Rezoning Transportation Analysis

Petition Number: 2020-112

Date	Description
09-11-20	First Review (EL)
04-15-21	Second Review (EL)

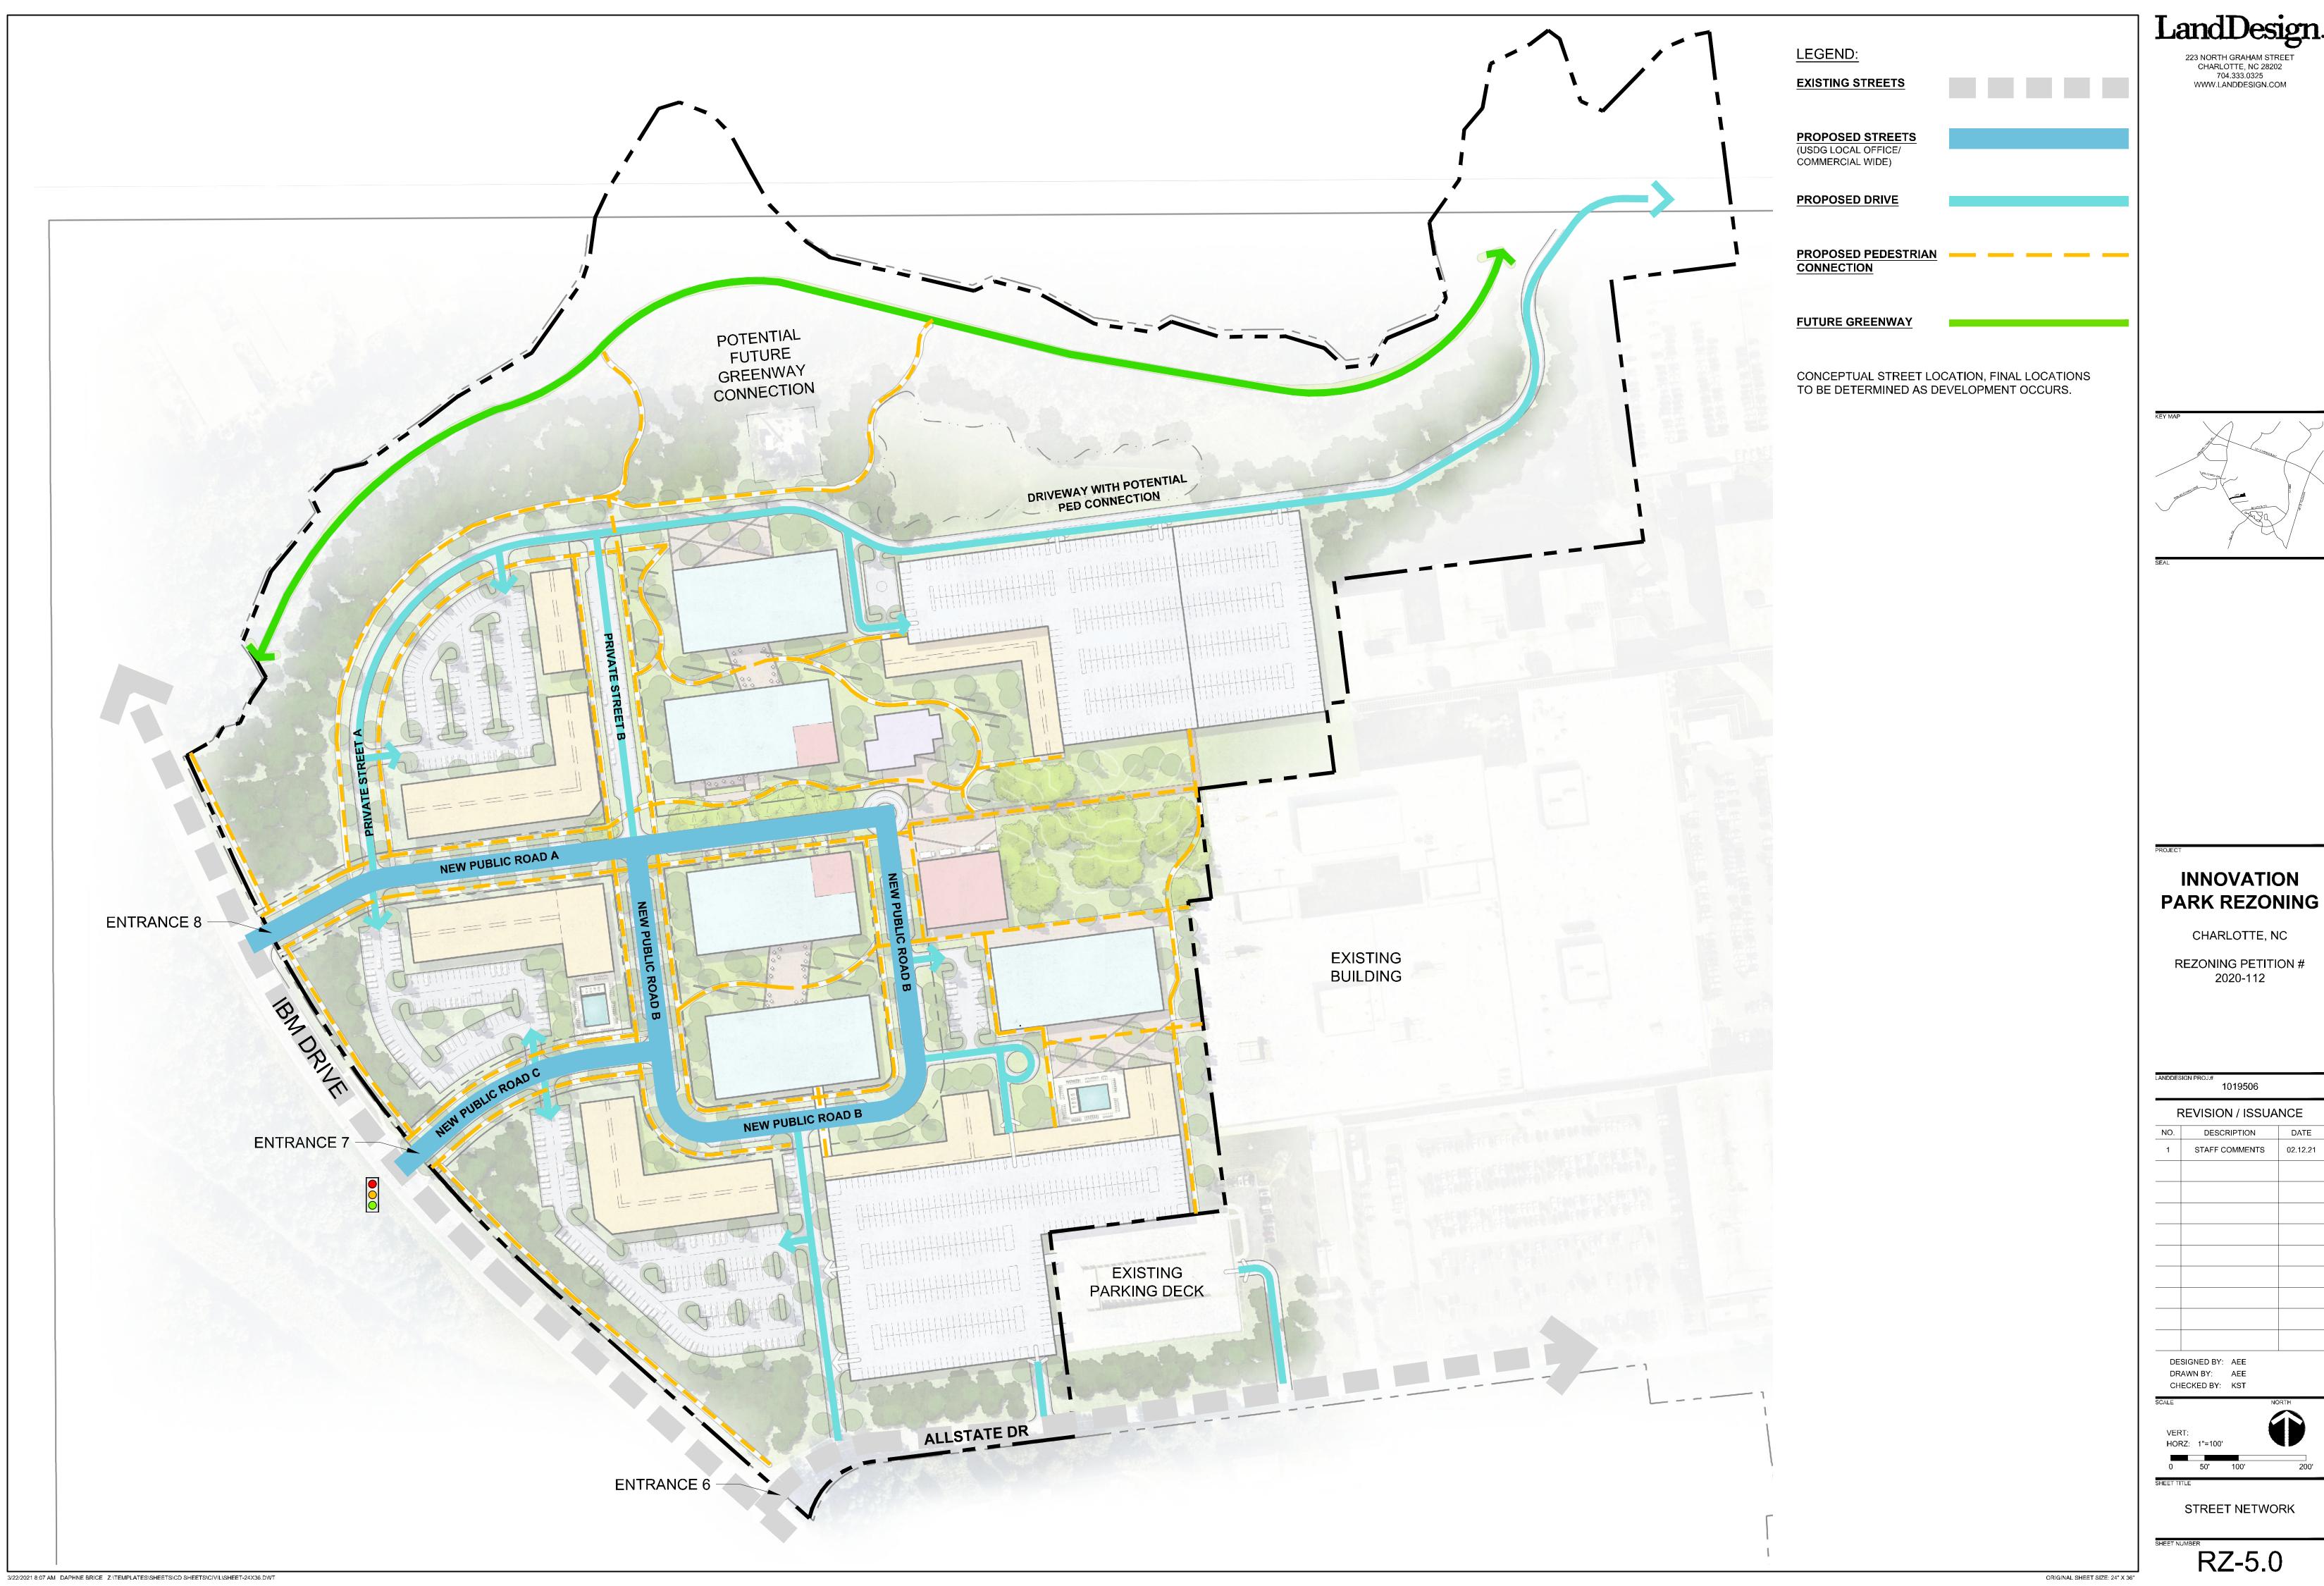
- 8. **New comment** (site plan dated 2021.04.15): The site plan and conditional note(s) need to be revised to renumber the intersections to match the TIS scope that was approved 3/9/2021.
